Re: Cobaki Estate – Project Approval 08_0200 Mod 2

39A Fencing of Environmentally Sensitive Areas – Precinct 9 and 11 Earthworks

Having regard to the above we request that the attached fencing plan replaces that at Appendix A of the VMP, and that Condition 39A be replaced with the following:

Attached is a plan showing those lengths of fencing in the current approval which are proposed to be omitted in the amended approval.

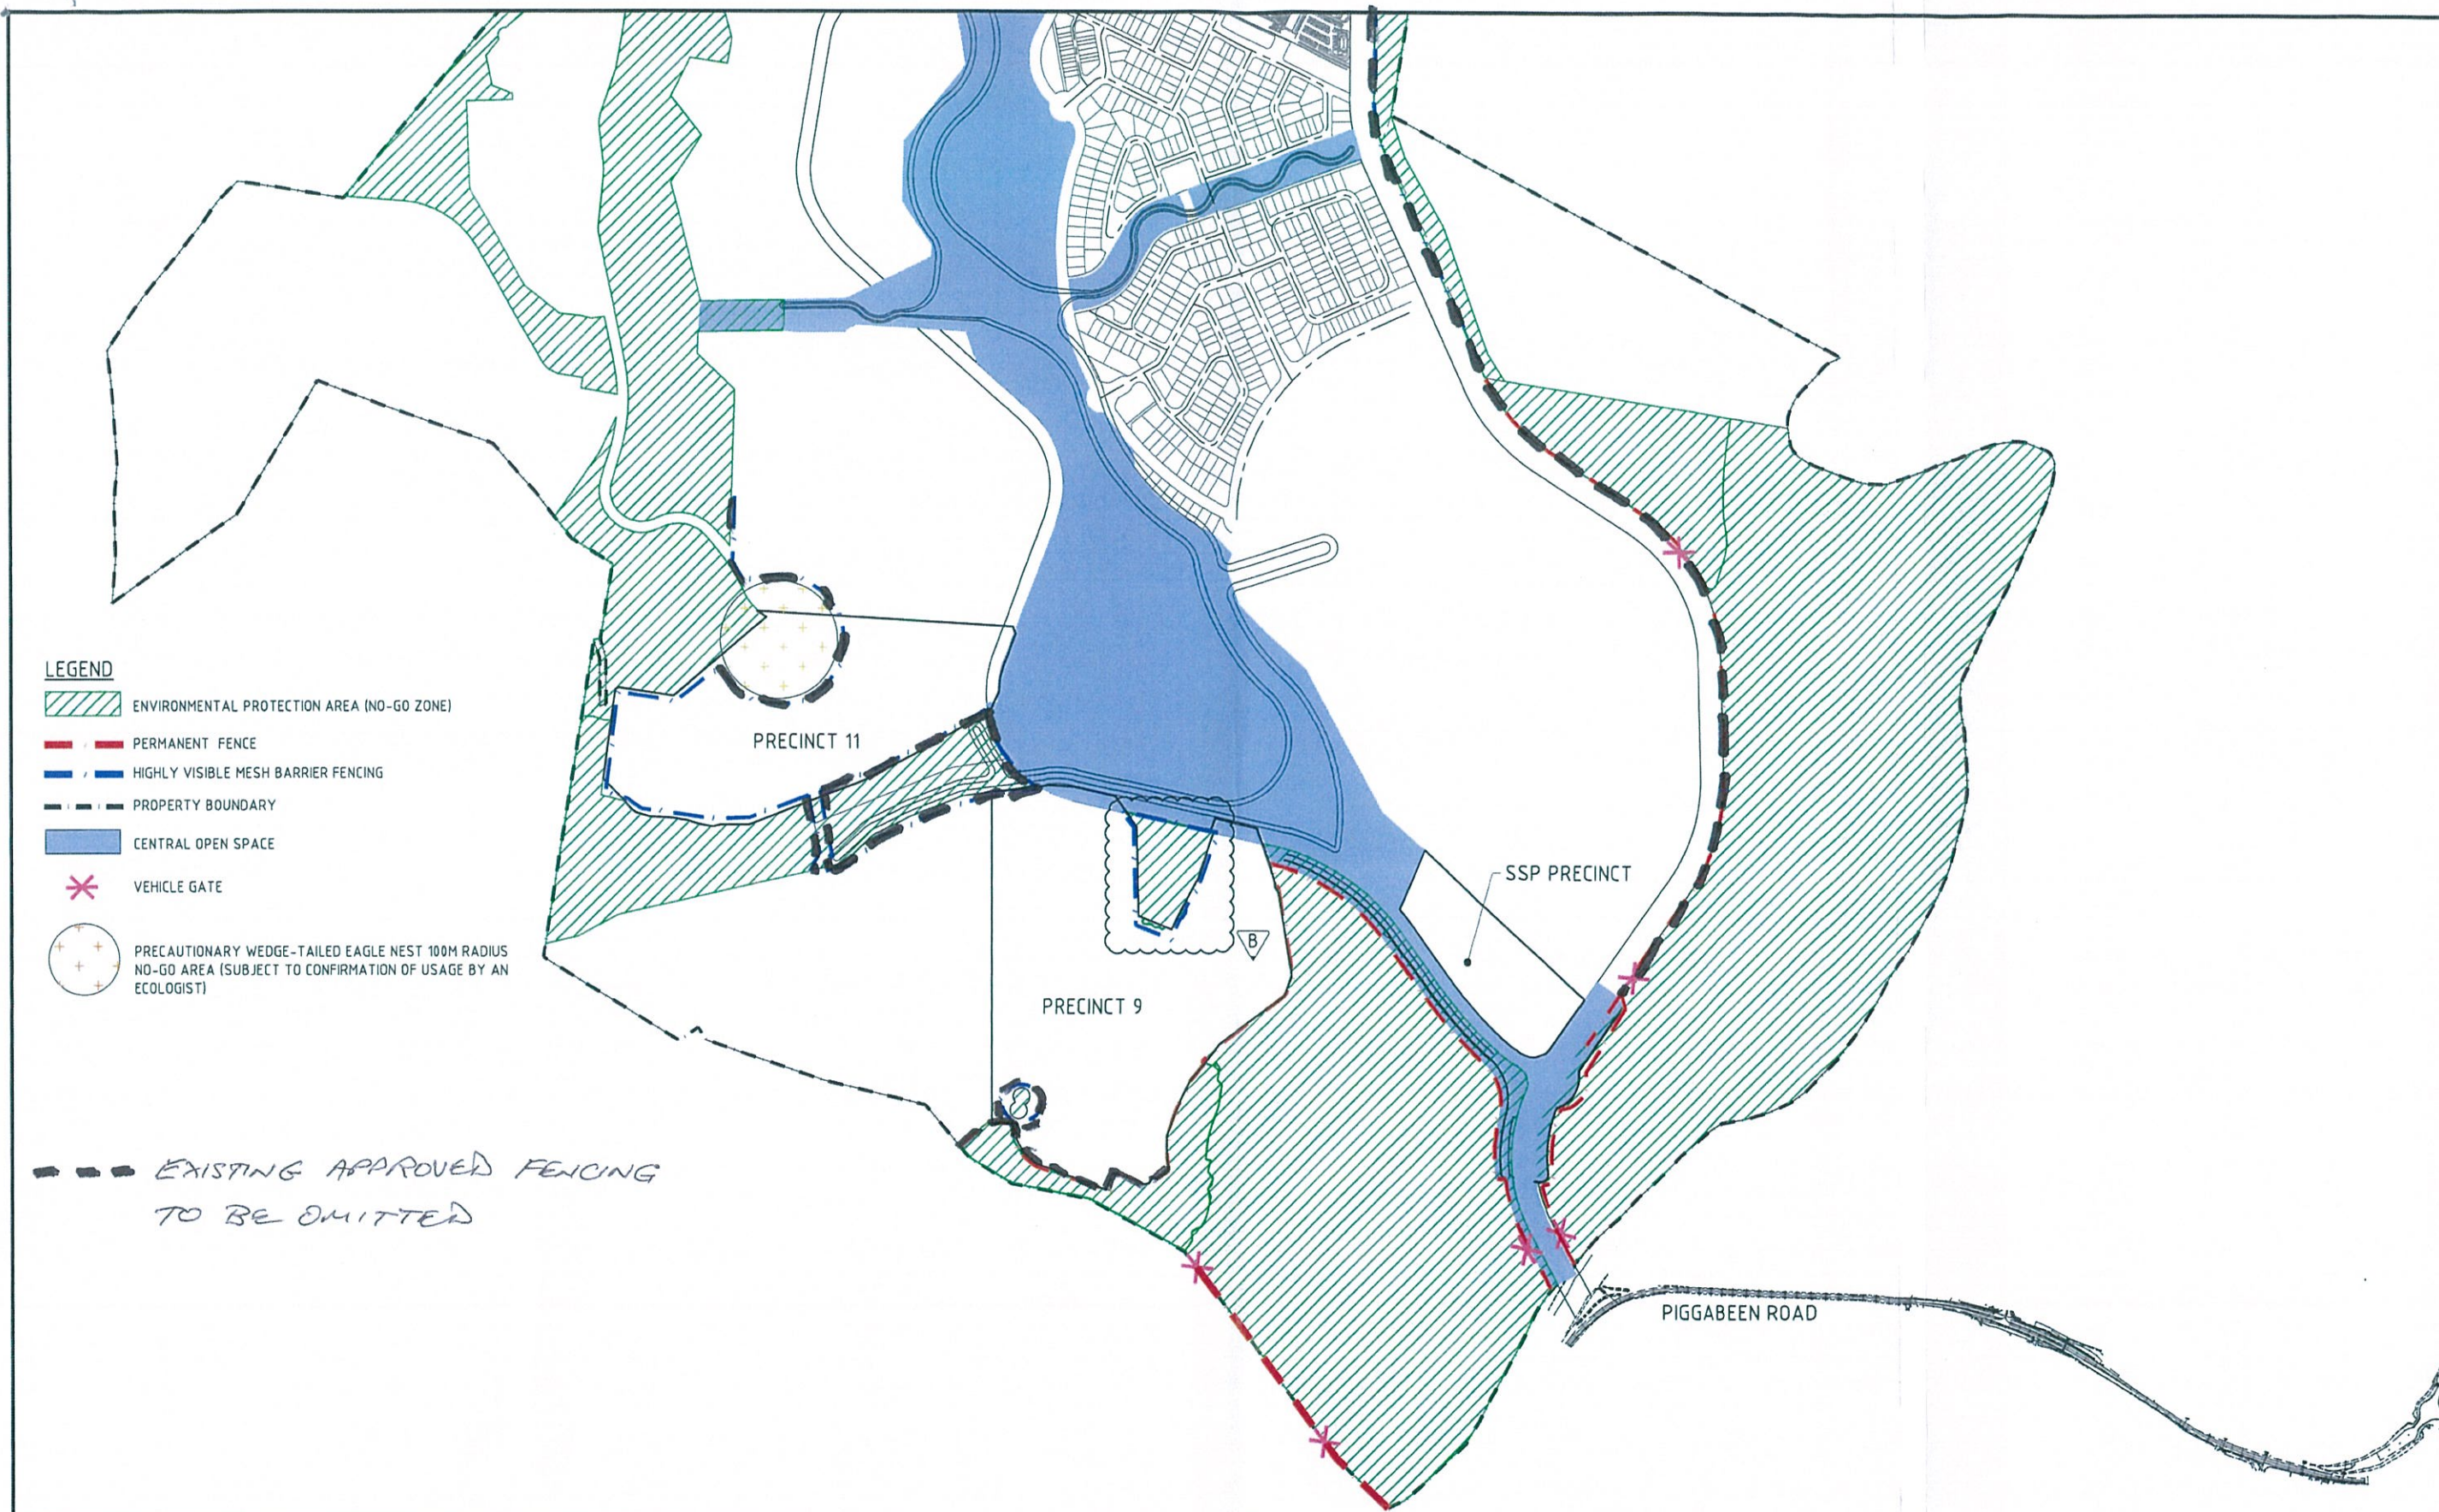
The fencing plan at Appendix A of the VMP does not correctly capture these requirements. We explain why with reference to the attached copy of the plan.

- Area 1 is not "environmentally sensitive"
 - The site Revegetation and Regeneration Plan (James Warren & Associates, October 2010) which formed part of the Concept Plan Approval includes
 - figure 9, Condition Assessment, in which the condition of this area is assessed as "very poor".
 - figure 4, Rehabilitation and Management Precincts, which proposes this area for *revegetation*, and
 - figure 5, Endangered Ecological Community Offset Areas, which then proposed the area partly for Freshwater Wetland (within the indicated proposed drain lines) and the balance for Swamp Sclerophyll.

Area 2 is to be protected by covenant in order to preserve two old growth trees. However, the area has nothing to do with the works intended under the Mod in question.

This area of fencing is not adjacent to, or close to, the borrow pit in Precinct 9 the subject of the Mod.

These lengths of fencing are not connected with the filling of the *Central Open Space*.

The tree containing the raptors nest, which our Environmental Officer had determined was no longer being utilised, is wrongly located in the fencing plan referred to. It was actually located at the edge of the adjacent environment zone, but was felled by a person or persons unknown in December last year.

The boundaries of environmentally sensitive areas in accordance with “Fencing Plan Precinct 9, 11 Borrow Areas Drawing No. 3310071E-044(2)”, together with the 5m buffer to existing threatened flora species within Vegetation Management Areas 7 and 8, shall be surveyed and appropriately marked with either high visibility netting barriers/fencing or permanent fencing during Precinct 9 and 11 earthworks activities.

Figure 5: Cobaki Estate – Approved Earthworks Fencing Plan – MOD 2

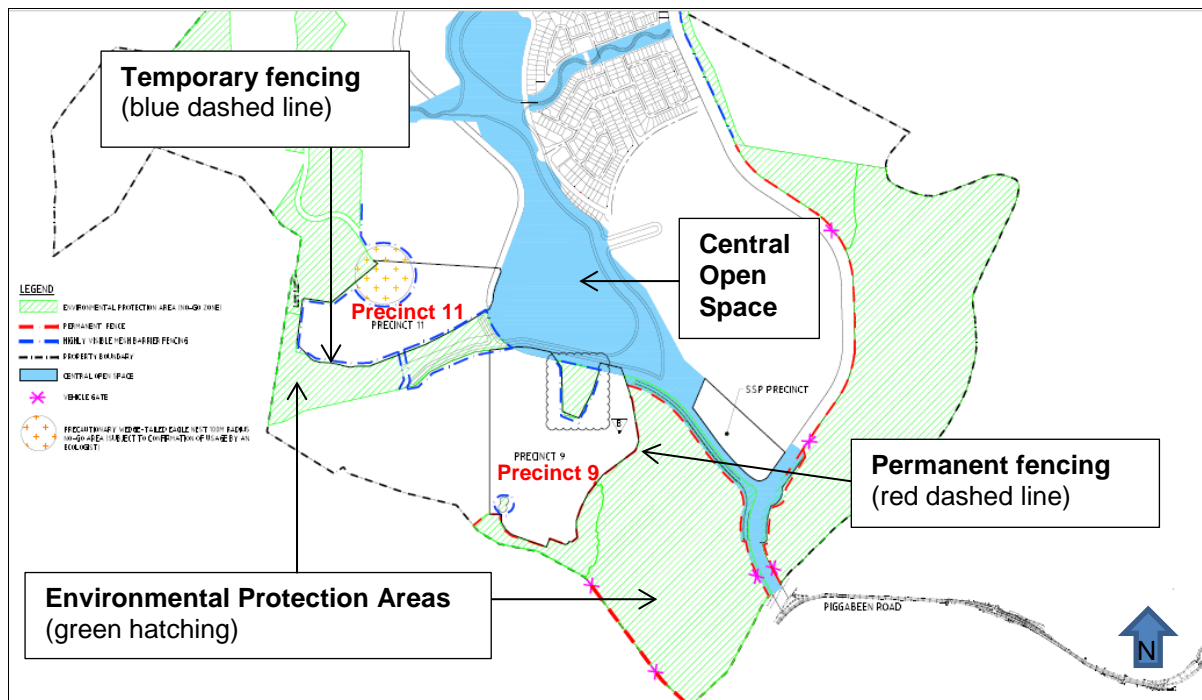
The fencing plan that became Appendix A to the VMP developed out of an earlier fencing plan for the *site as a whole*. Clearly, in hindsight, it did not properly reflect the intent of Mod 2.
